**Planning Department
Transportation Development Services**

**Re: Lamar Albuquerque
1600 Airtech Court
Traffic Circulation Layout
Engineer's/Architect's Stamp dated 7-15-15 (M16-D024J1)**

Based upon the information provided in your resubmittal received 7-14-15, the above referenced plan cannot be approved for Building Permit until the following comments are addressed:

A1.05

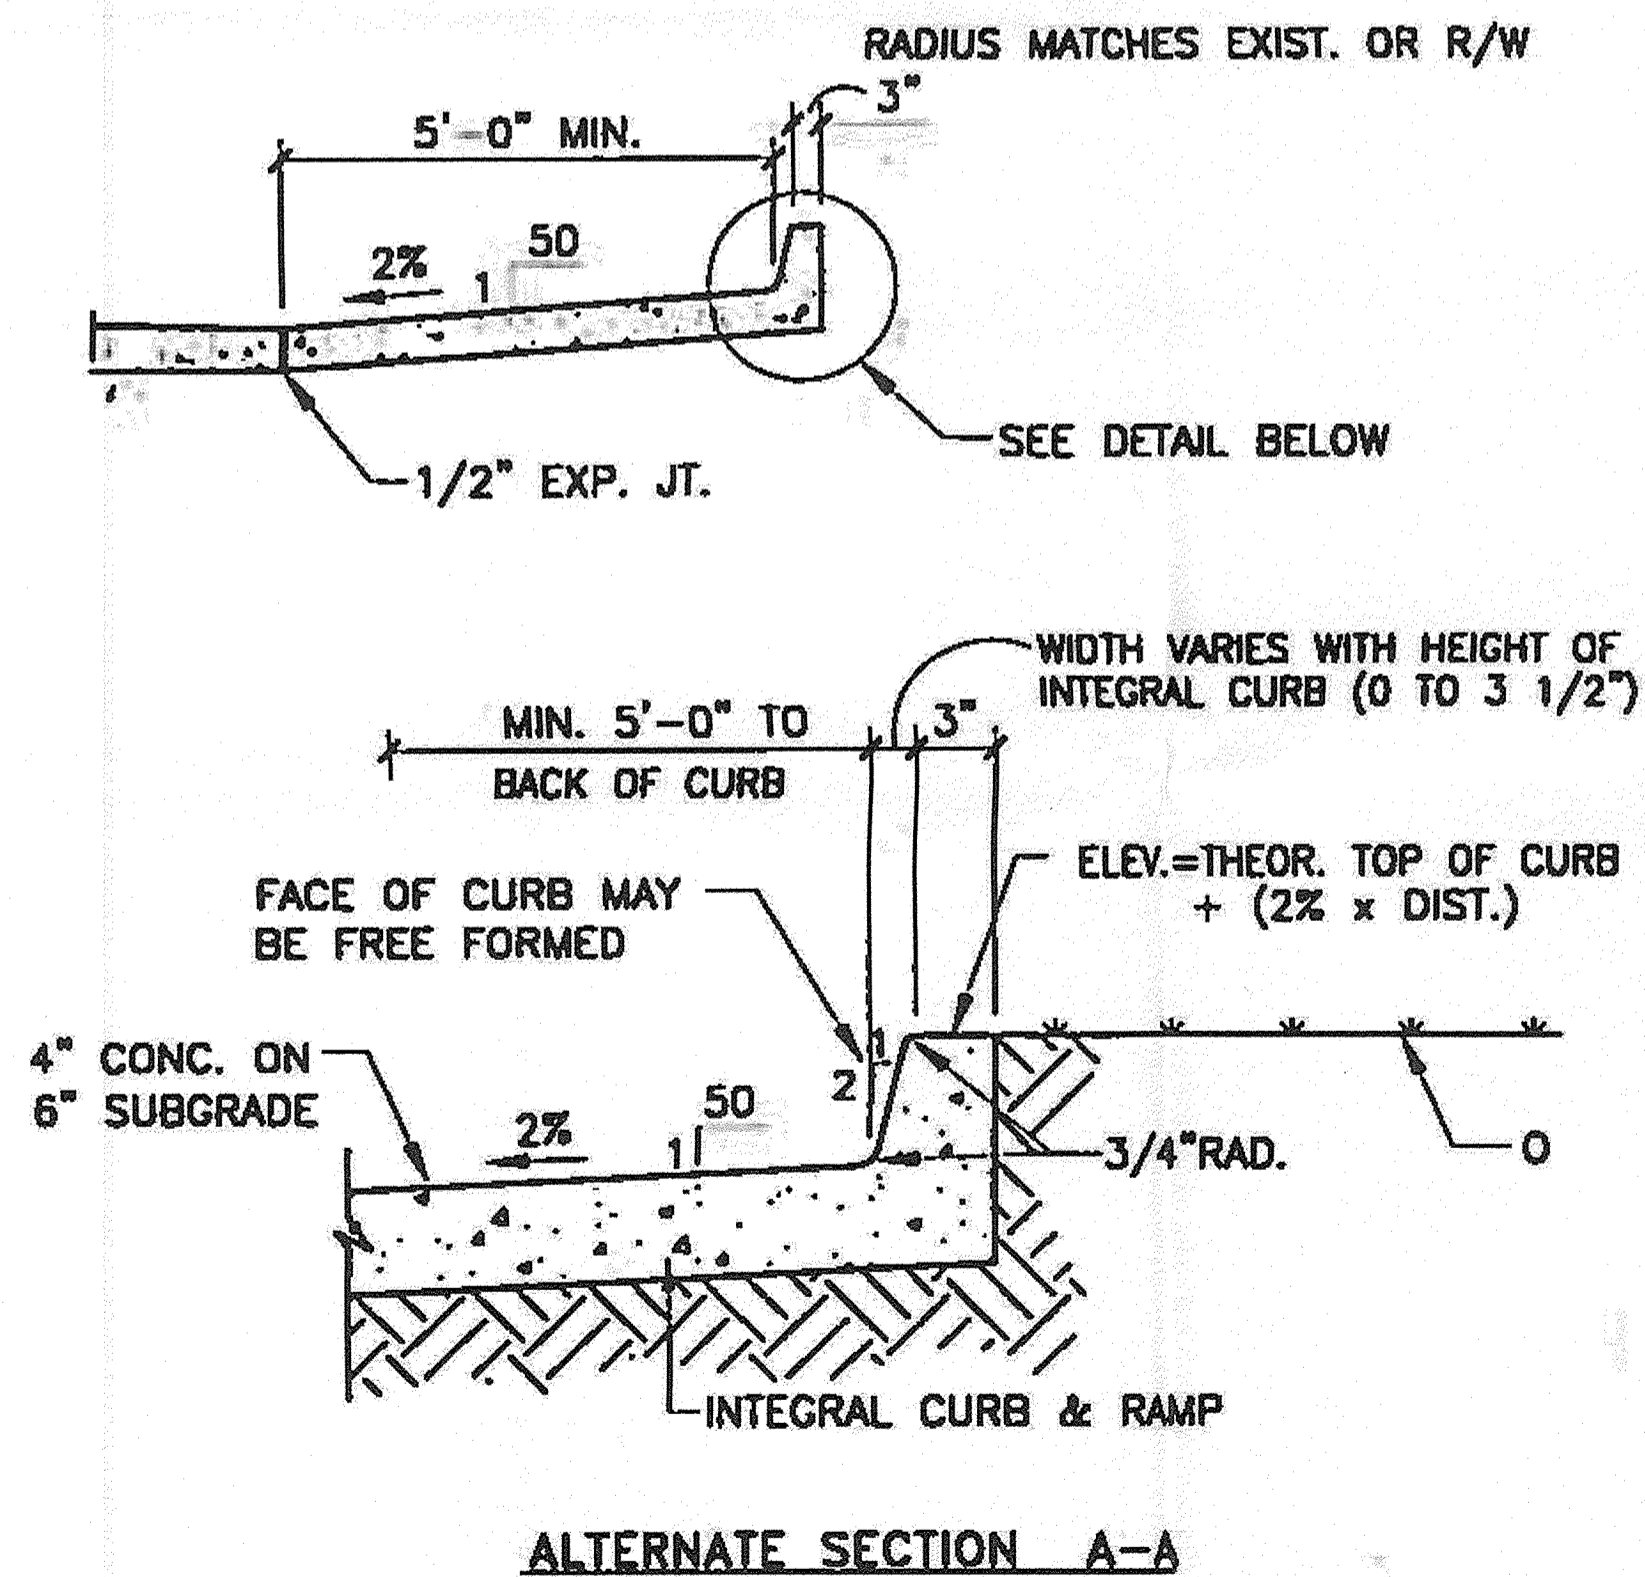
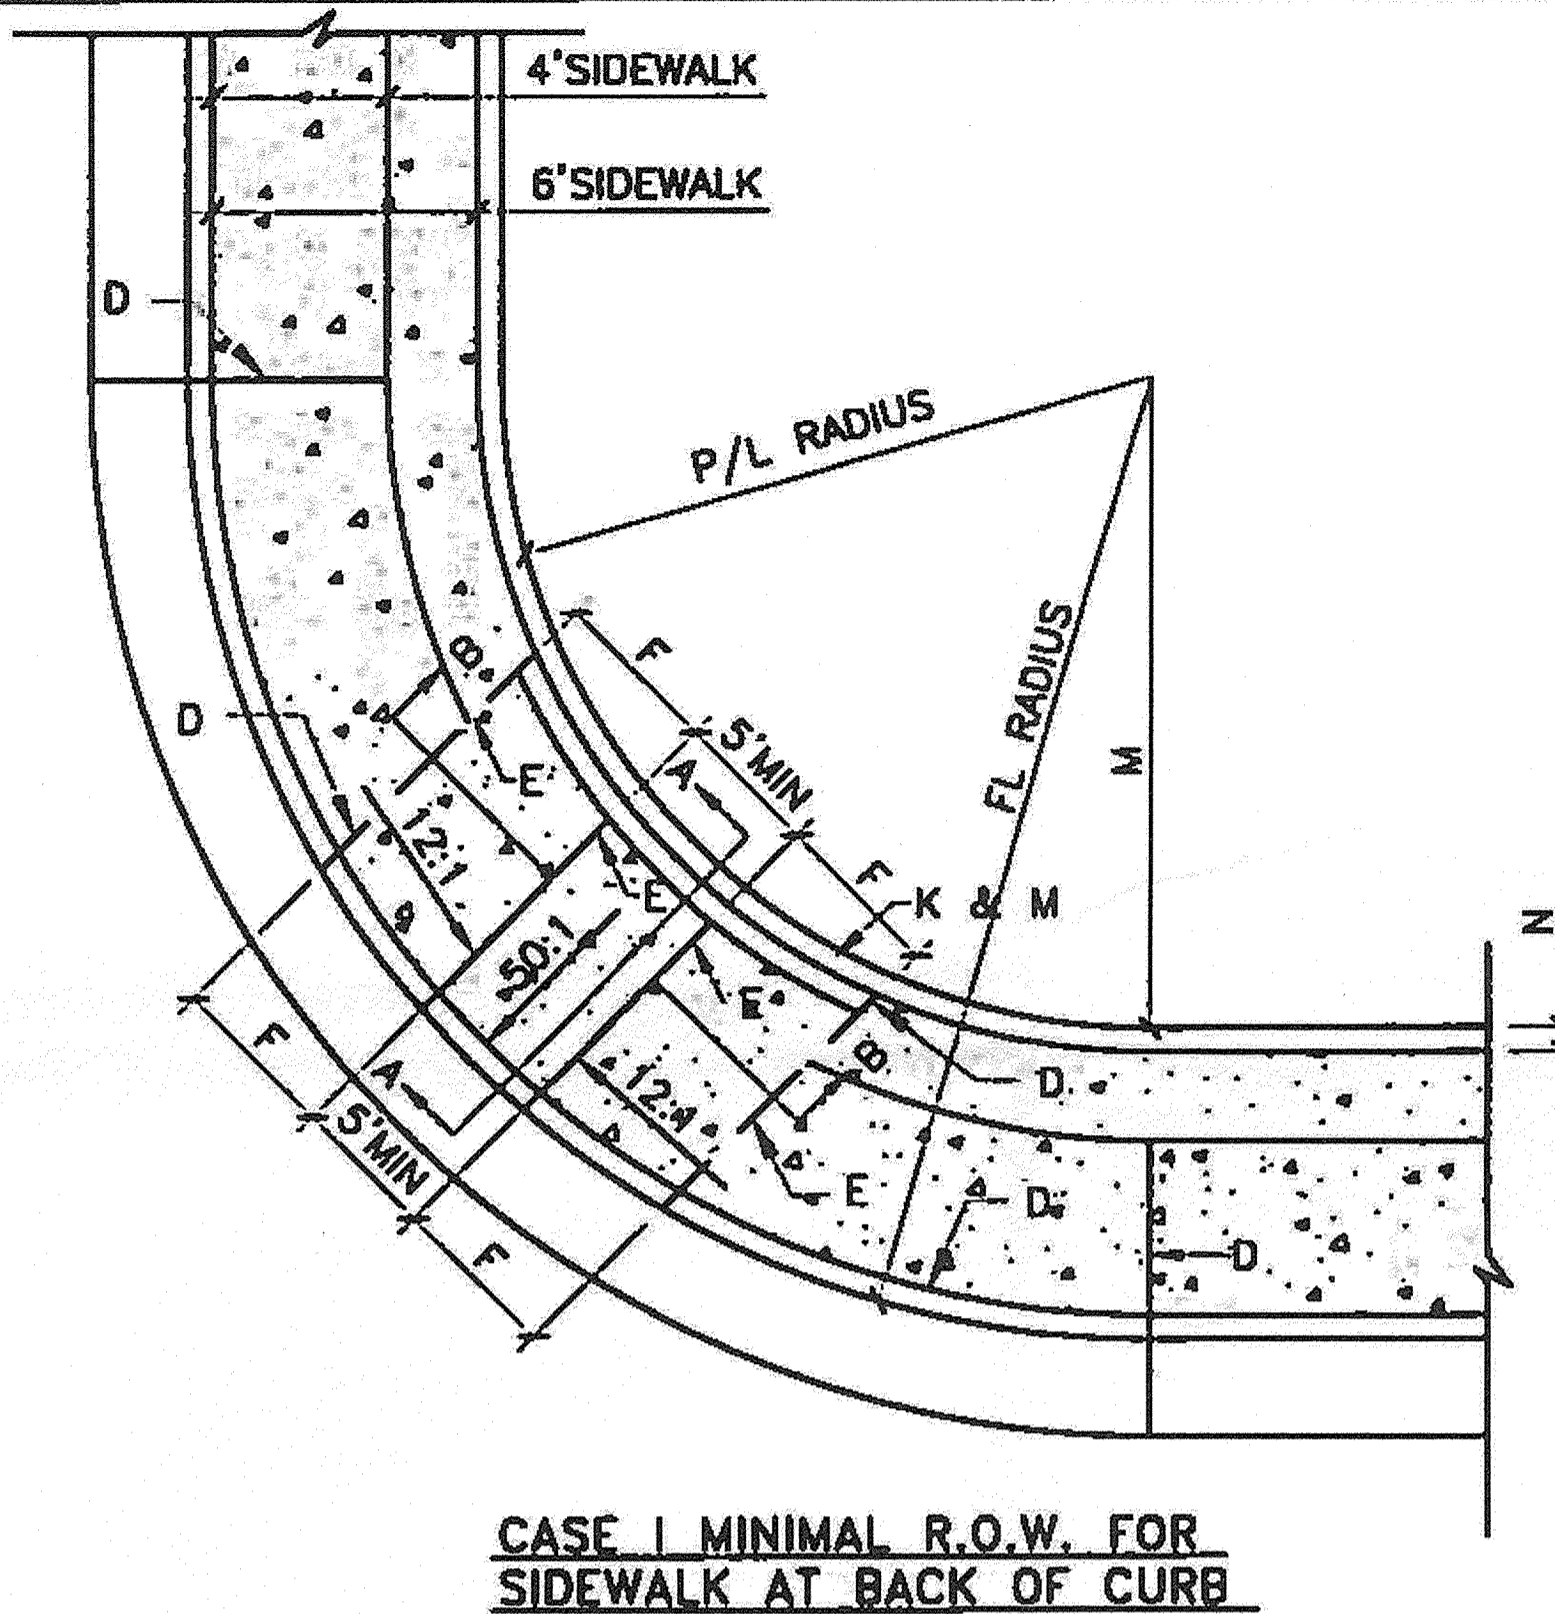
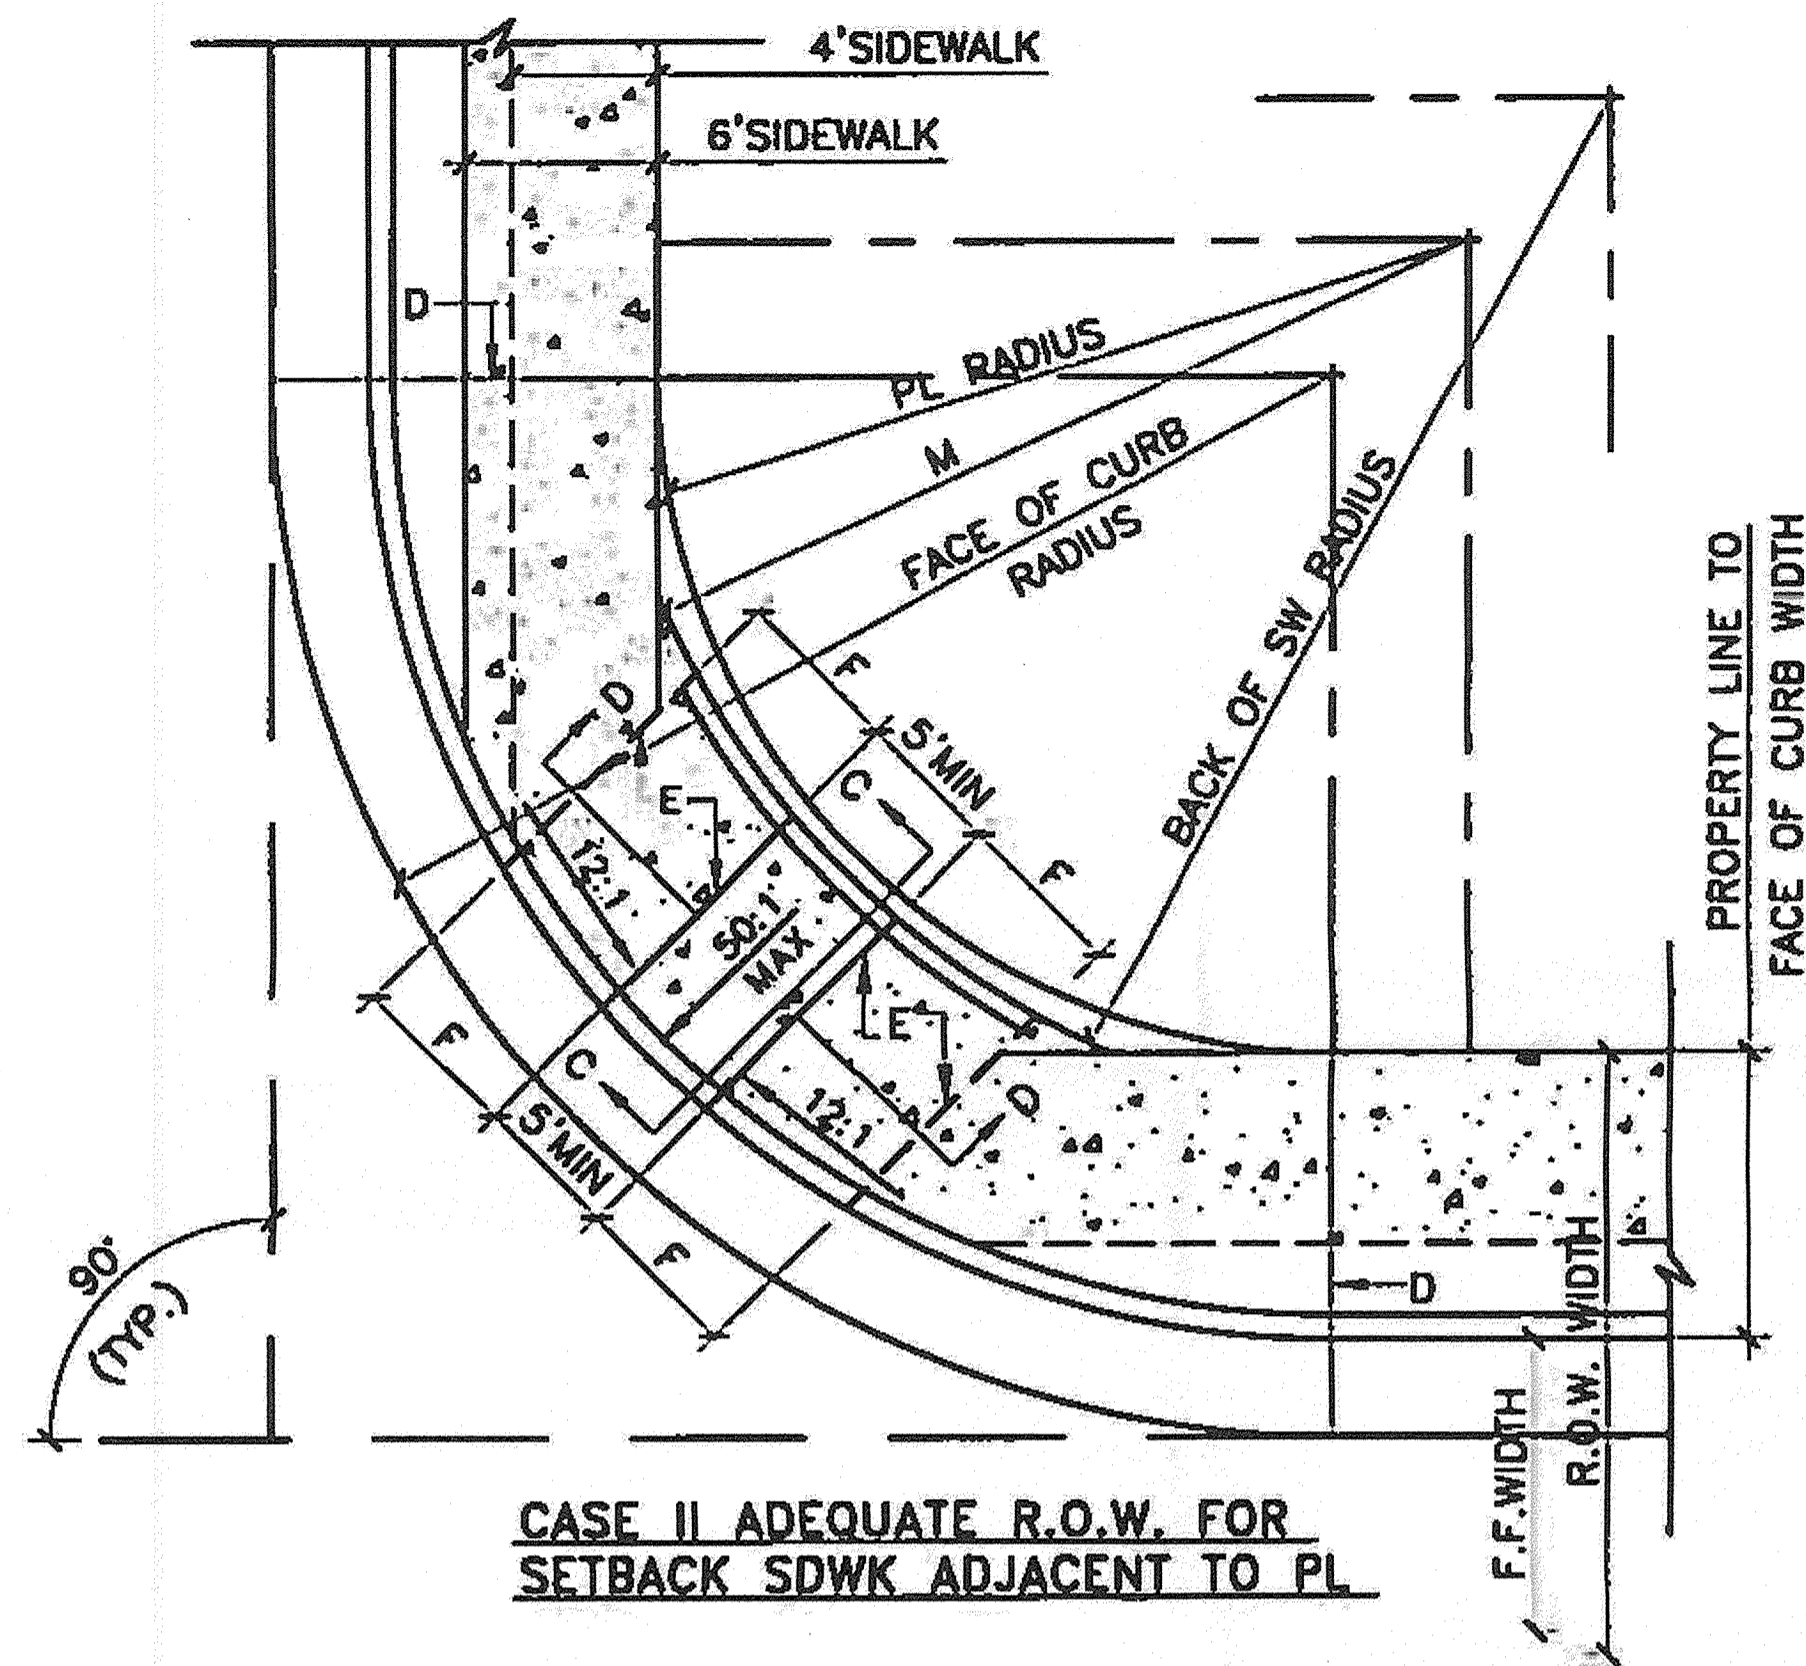
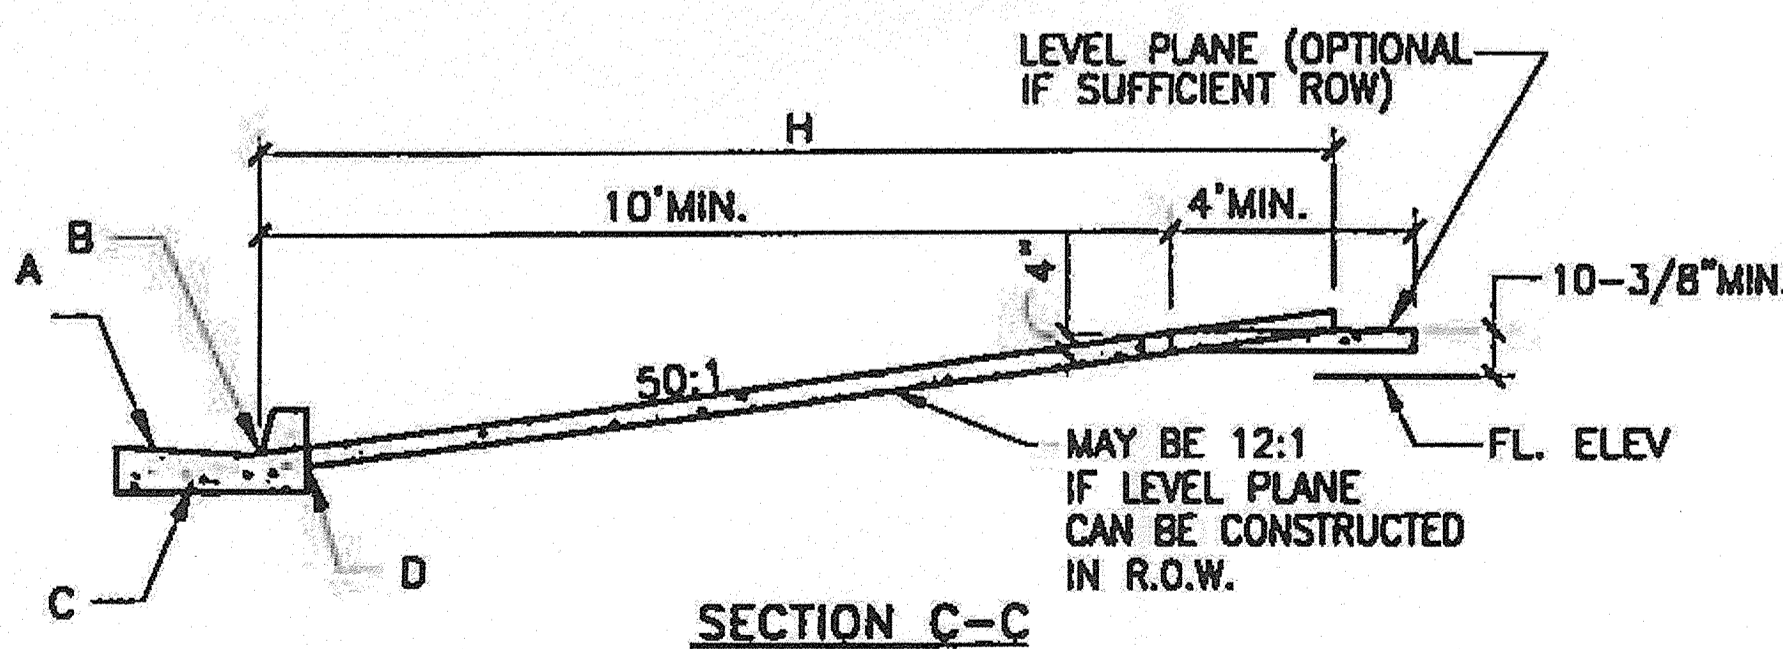
1. Please show a vicinity map showing the location of the development in relation to streets and well known landmarks. Please show a directional arrow.
2. Please show the extent of the project site. Please show the property line, fencing and any other development on the south side of the proposed project site.
3. Per ADA requirements ANSI 502.5, ADA parking spaces must have and unobstructed 8ft. wide by 18 ft. in length. Upon review of the submitted drawings, the wheel stops will be obstructing the total length of the ADA parking spaces.
4. Per DPM, the site must provide bicycle parking space and signage. Per COA Zoning requirements, there must be one bicycle space provided for every twenty automobile or light truck spaces. Please detail location of bicycle parking drawing.
5. Please include two copies of the traffic circulation layout at the next submittal.
